RE: PR-2020-003887, 2818 4<sup>th</sup> St NW, Site Development Plan for Building Permit

I am writing in response to the review comments dated December 8, 2020 and to request the vacation of the sewer easement.

DESIGNED	PROJECT NO
DRAWN	SCALE
CHECKED	DRAWING NO
REVIEWED	<b>A-100</b>
DATE	3/25/2021

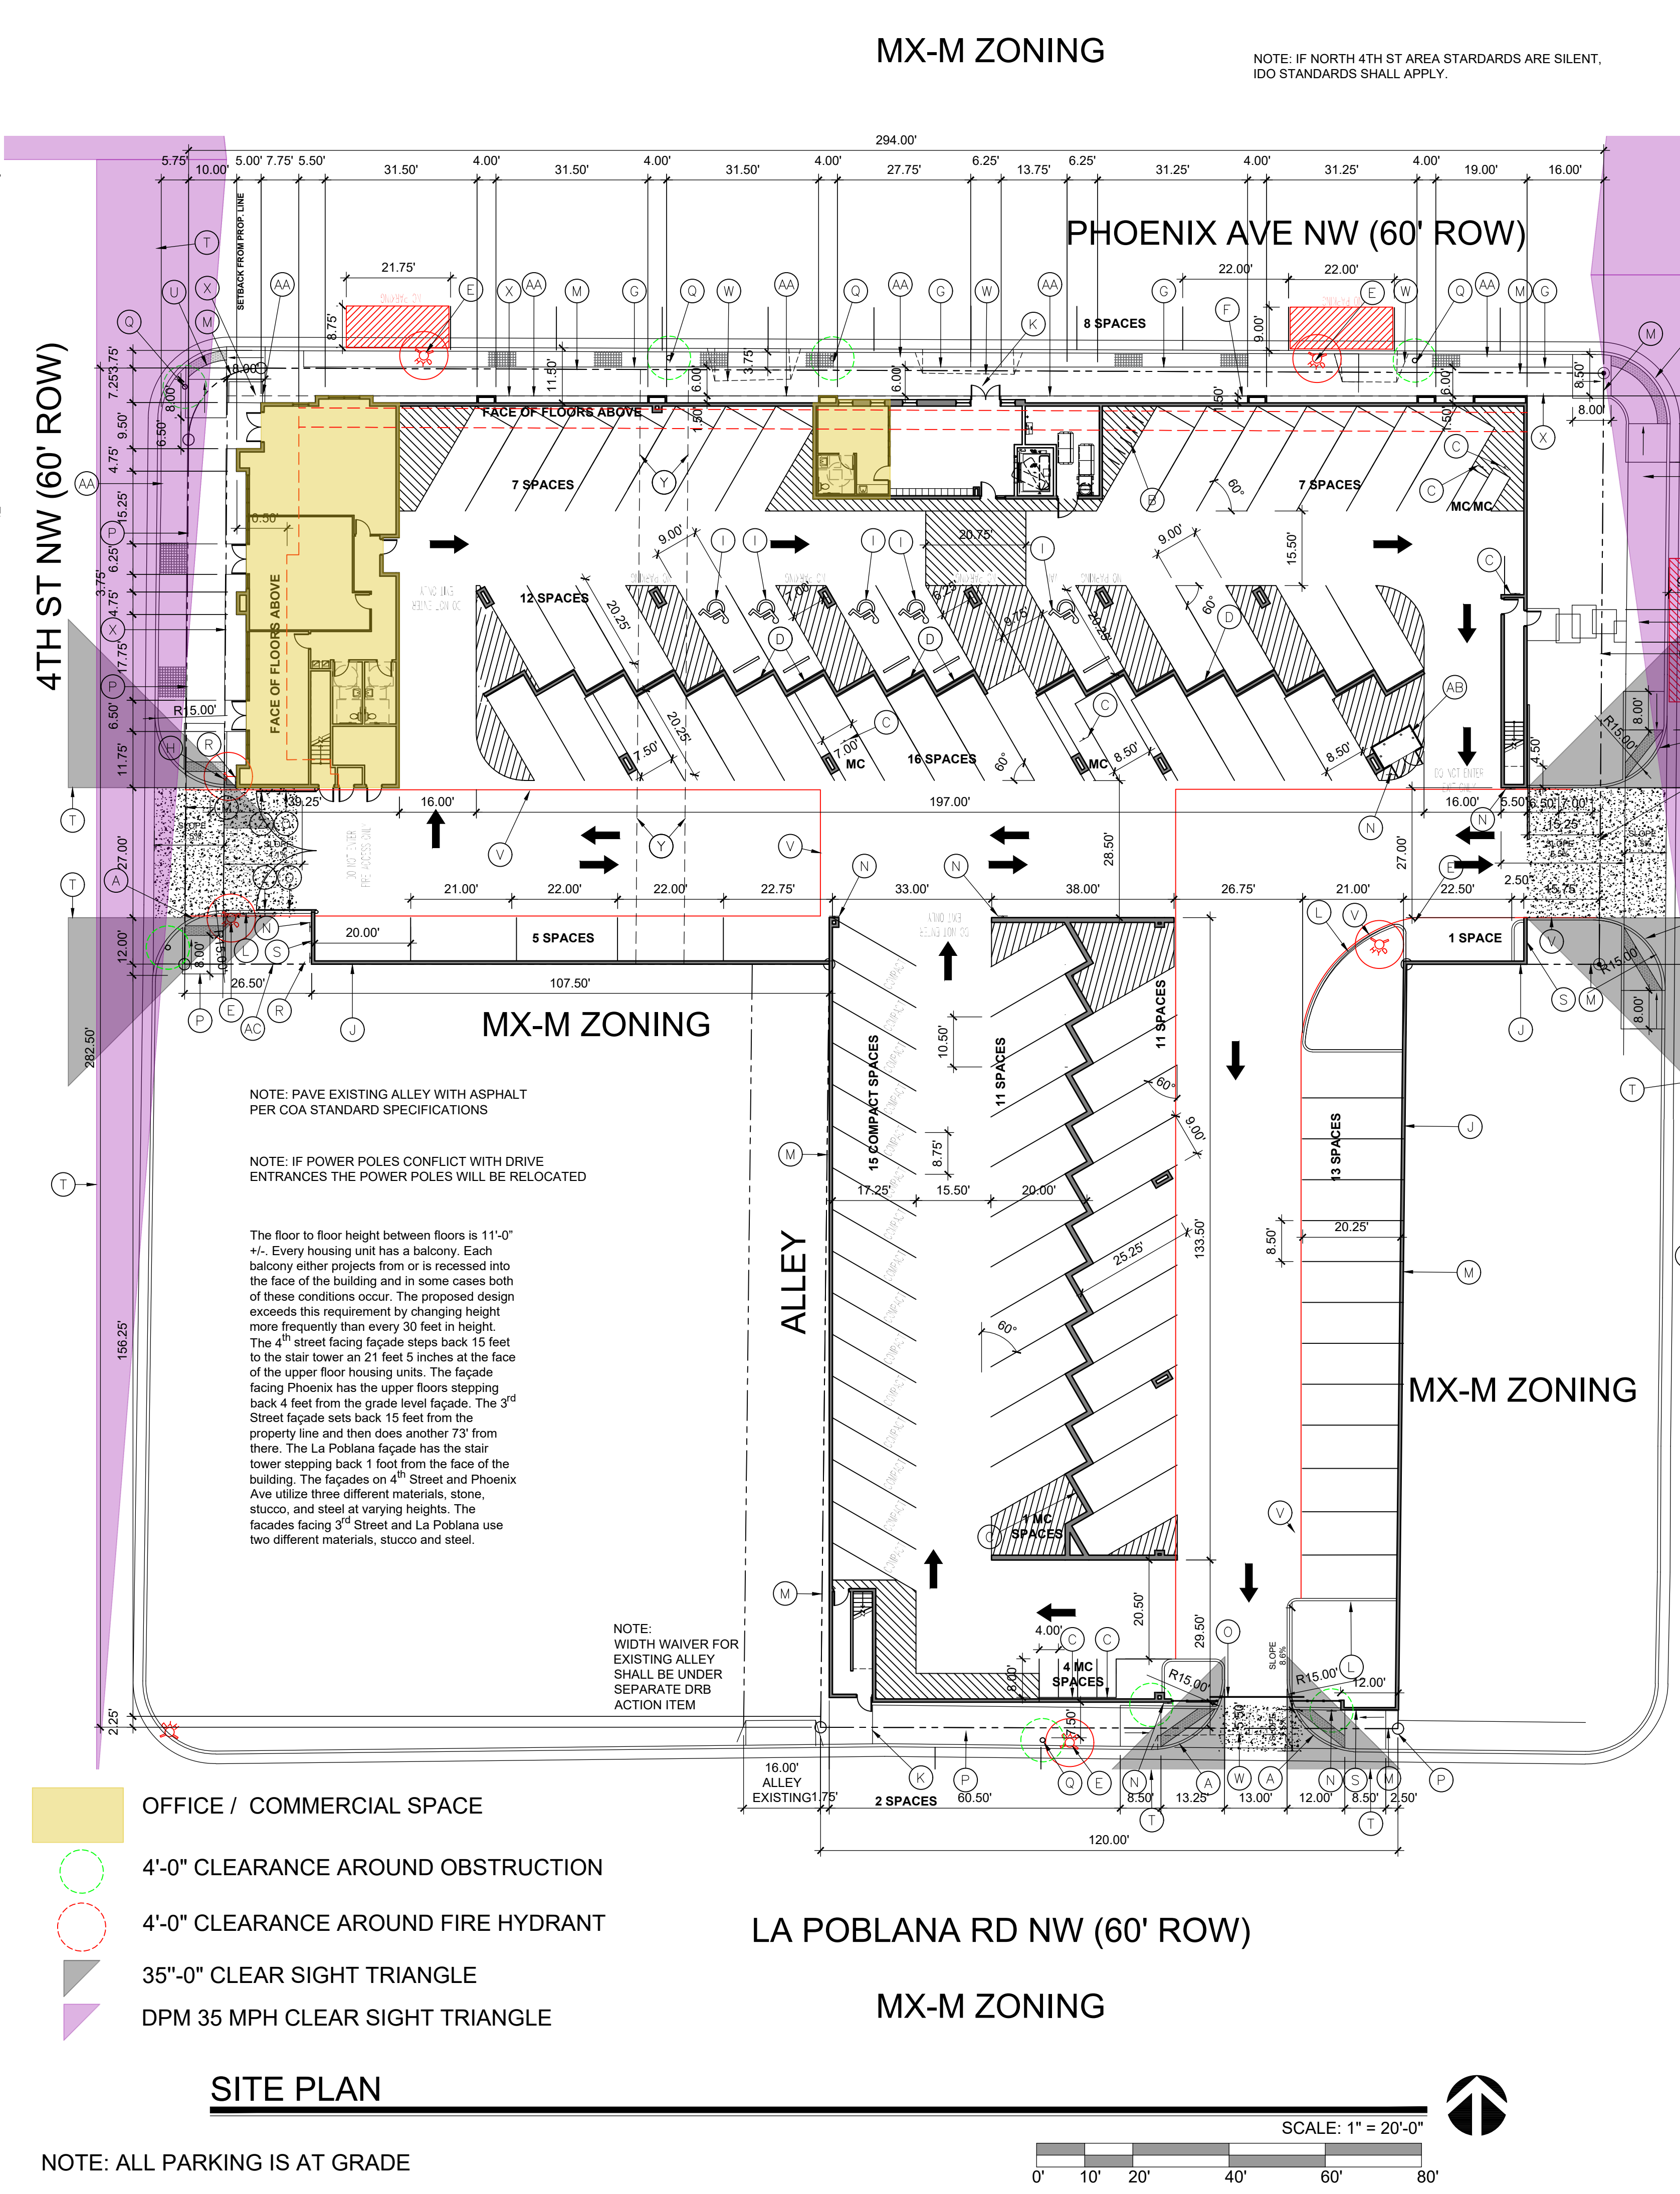
- 1) Show the sanitary sewer easement that is proposed for vacation. Platting approval is required prior to site plan approval.
  - a) Easement added and noted as keyed note "Y" on sheet A-101.
- 2) For driveway details added, show slopes and identify the driveway location on the detail sheet.
  - a) Parallel drive detail used, reference City of Albuquerque standard detail 2426. Keyed note "A" on A-100 revised to reflect this change. Drive entrances revised to coordinate with this detail.

- 3) With the gate moved back on the west entrance, still provide a queuing analysis. There may need to be a designated no parking area for two cars to que up.

- 4) Not all "Do Not Enter" signs are shown at the end of one-way aisles. Include these at the end of each of the one-way aisles.
  - a) "Do Not Enter" signs have been added to the inside face of the west entrance (reference keyed note "Z" on sheet A-100). Pavement markings and signs have been added to the drive at the NE corner of the building and to the drive at the north end of the drive on SW corner of the site.

- a) A waiver request for the alleyway will be made prior to the first DRB in January 2021.
- 6) It appears that the curb ramps at each of the corners does not meet ADA based on slopes, and detectable warning surfaces are required. Prepare an infrastructure list to show alleyway paving, public sidewalk, and preplacement of ramps at each of the intersection corners.

- a) Added, reference sheet A-100.
- 7) Each of the circles at demonstrates 4 foot width is very difficult to read. Darken these, and place in the legend. Be sure to include all obstructions.

- a) The west entrance is for fire department access only. The drive has pavement markings that state "DO NOT ENTER FIRE ACCESS ONLY", two signs indicating that this entrance is for emergency use only (keyed note R on A-100), and a do not enter sign (keyed not N on sheet A-100). The lane is also striped with a red fire lane indicating no parking.

- a) The 4-foot circles around power poles have been darkened and added to the legend. 4-foot circles have been added to the traffic signs on the south side of the property. The 5 foot clearance circles for hydrants has been added to the legend.

DESIGNED	PROJECT NO
DRAWN	SCALE
CHECKED	DRAWING NO
REVIEWED	<b>L-101</b>
DATE	3/25/2021

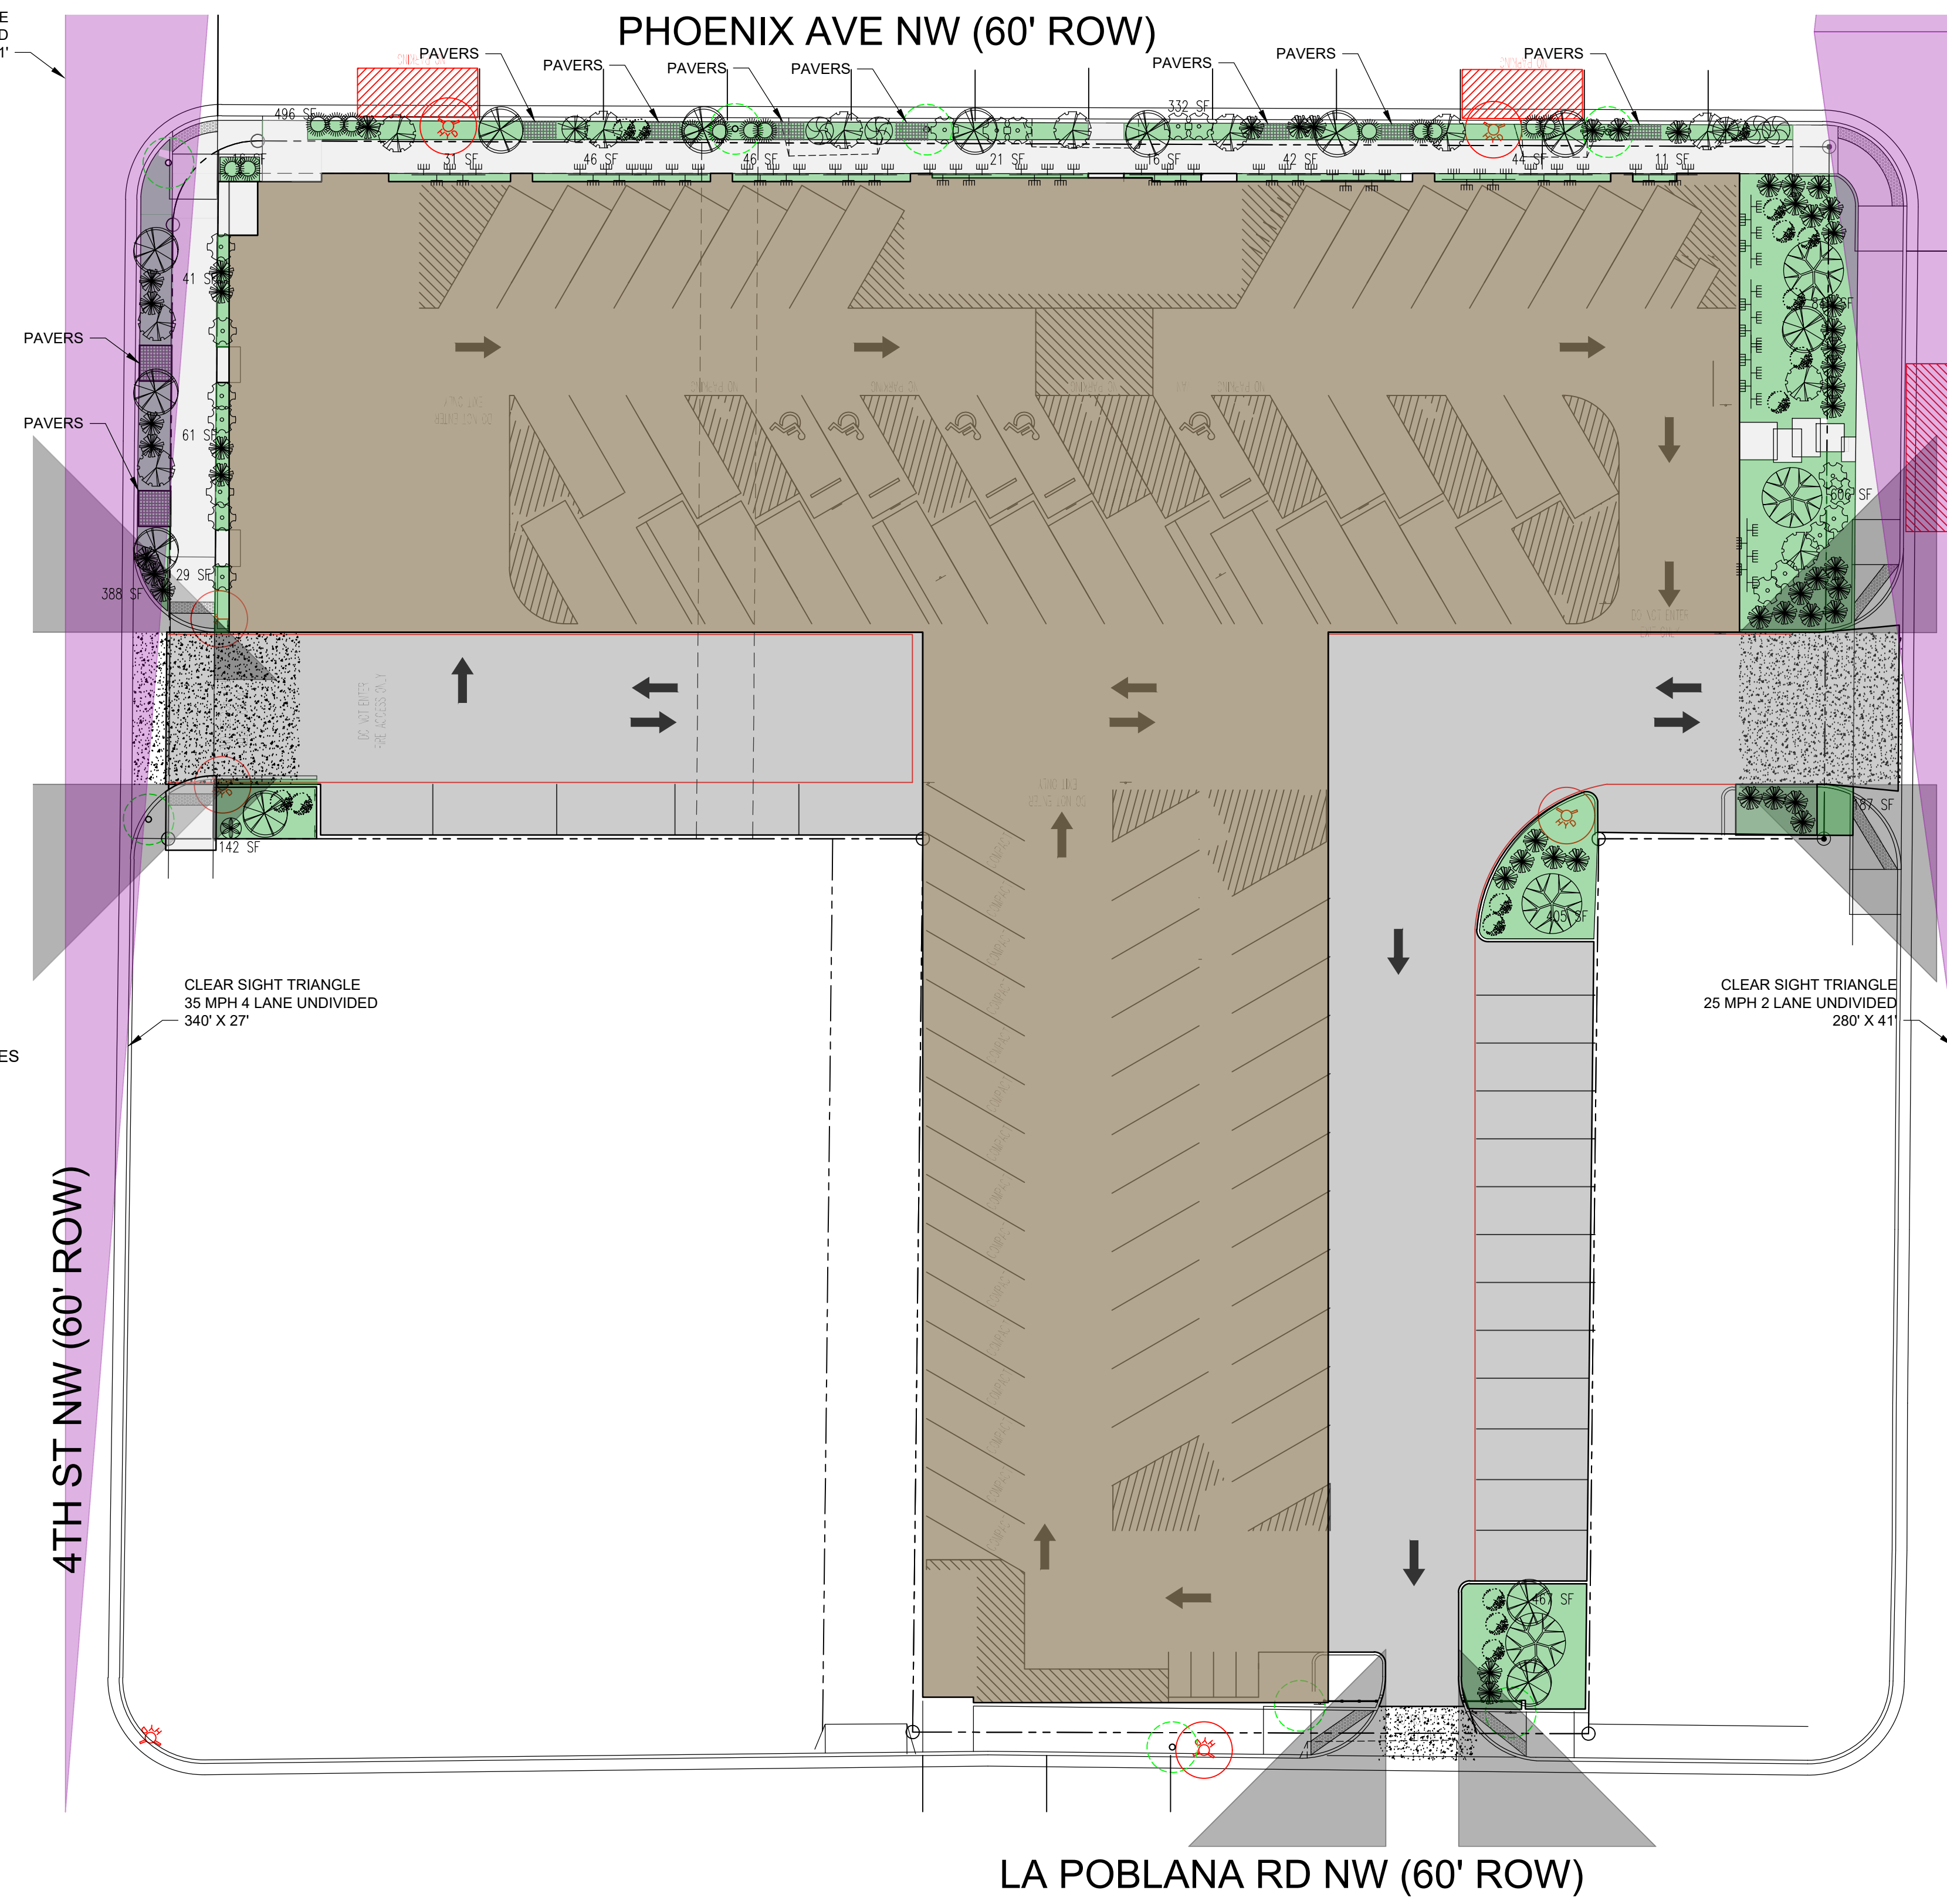
- 1) The landscaping requirements must comply with the use-specific standards for multi-family dwellings per 4-3(B)(7)(a) as follows:
  1. At least 50 percent of the trees required by Subsection 1 above shall be deciduous canopy-style shade trees or coniferous trees capable of attaining a mature canopy diameter of at least 25 feet.
  - a) The number of trees required exceeds the minimum, reference calculations sheet L-101. The shade requirement cannot be met due to PNM restrictions. In a letter to Scott Anderson and Jay Rodenbeck dated December 7, 2020, PNM states the following:

- b) The site plan reflects changes to the landscaping plan to conform to sheet 15 of 28, Appendix 1, City of Albuquerque Council Bill R-19-162.
- 2) Solid Waste signature will be required for this Site Plan, and their signature is encouraged prior to the DRB Meeting. Prior to DRB members signing the Site Plan, the required signature from Solid Waste and AMAFCA must be obtained.
